Modifications to Accor Sofitel Hotel Site 4A, Olympic Boulevard Sydney Olympic Park

SECTION 75W APPLICATION

Submitted to: NSW Department of Planning

Date: 17 January 2007

Project
SO F I T E L
SYDNEY OLYMPIC PARK
OLYMPIC BOULEVARD HOMEBSH
CHANGES TO EA-APPROVED FACADE
WEST ELEVATION

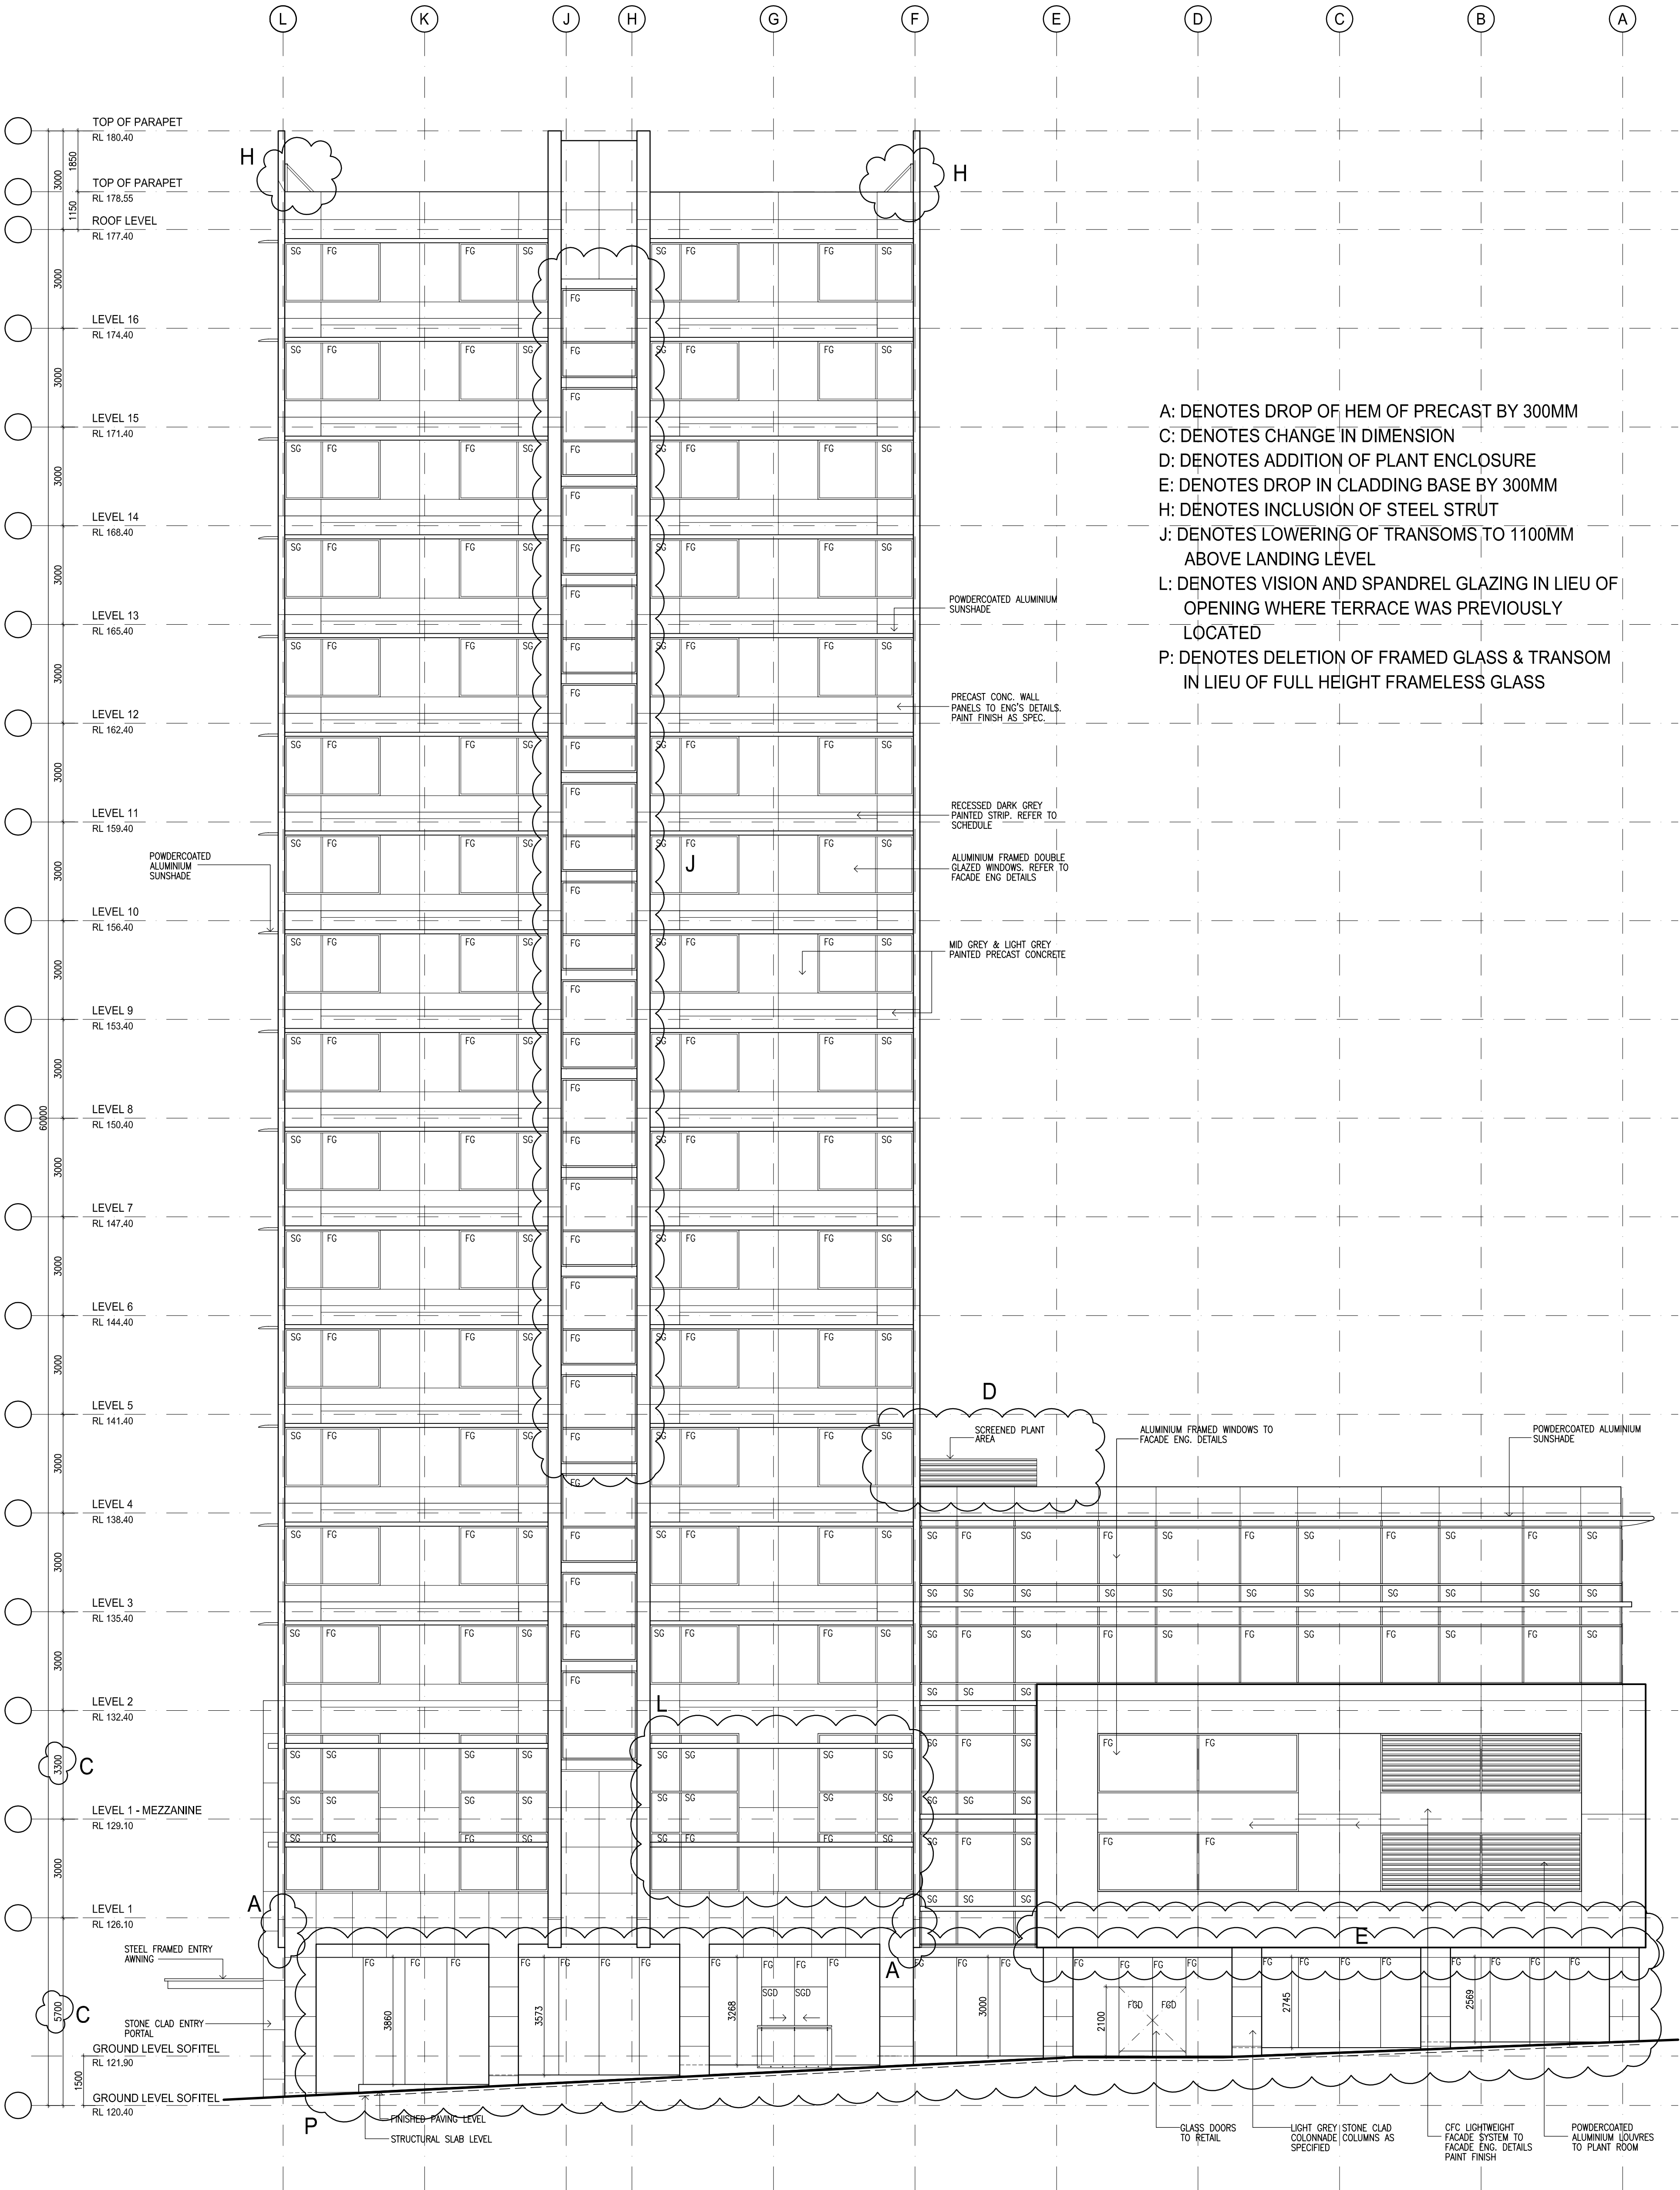
- A An increase to the floor to floor height of the mezzanine level by 300mm with a subsequent reduction in the floor height on the ground level also by 300mm. This modification has occurred to provide sufficient mechanical services reticulation to the public spaces on Level 1. There is no overall increase in the building height, simply an alteration of heights between the Ground Floor and Mezzanine levels to accommodate services. The effect of the modification is a drop in the hem of the precast panels of the main north and south facades.

- E In reference to comment A, the baseline of the adjacent lightweight cladding was reduced by 300mm in order to maintain the original continuity of lines around the base of the building.

- G Inclusion of ventilation louvres as noted on the building facades.
- H The inclusion of steel struts at the top of the parapet above roof level. The struts will be finished in the same colour as the precast panels and the bulk of the structure is located below the adjacent lower parapet to eliminate the diagonal brace. The struts are required to support the cantilevered parapet walls. Further detail is provided on sketch detail SK-46 prepared by Hyder Consulting (See Appendix 2).

Project
SOFITEL HOTEL
SYDNEY OLYMPIC PARK
OLYMPIC BOULEVARD HOME BUSH
CHANGES TO EA-APPROVED FACADE
SOUTH ELEVATION

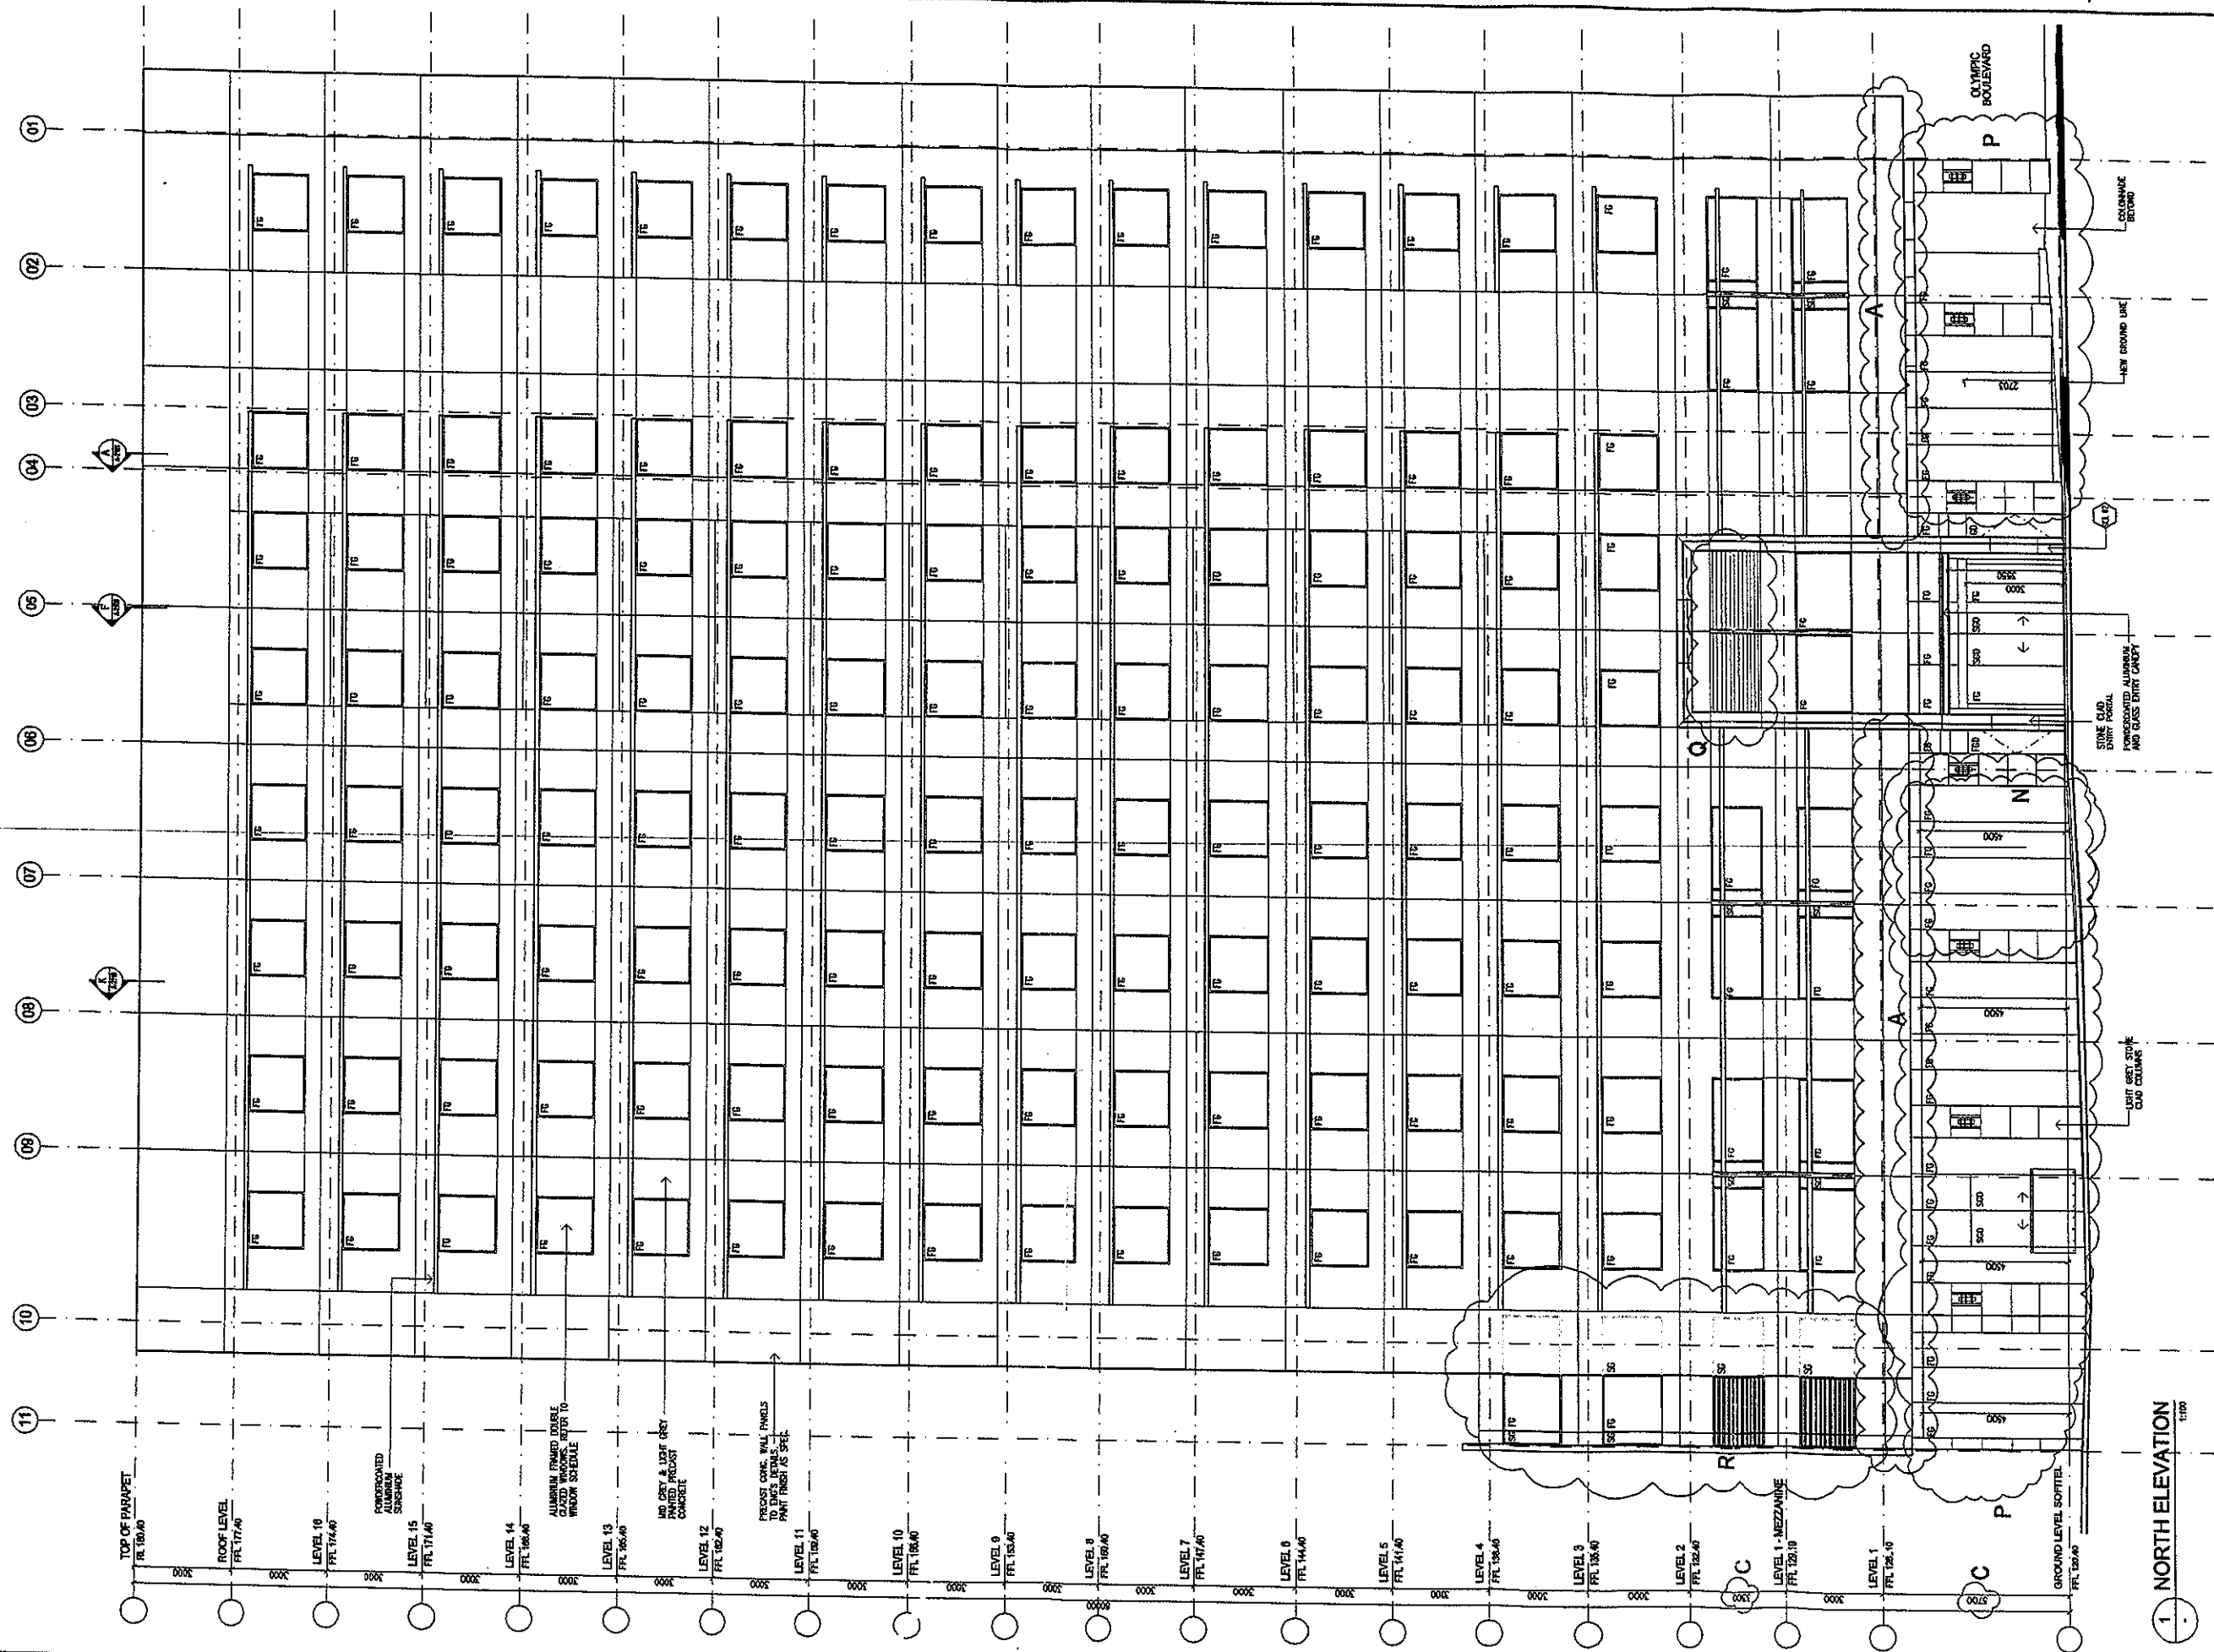
- O Not used
- P It is proposed to change the ground floor glazing to the restaurant, bar, lobby, reception and retail areas to full height frameless glass. This is to increase activation of these space and interrelationship with the public domain.

- Q Aerofoil louvres are proposed above the main entry portal and are required for the termination of the main smoke exhaust system for the public areas of the building. Sketch details SK-47 and SK49 provide further information (Appendix 2).
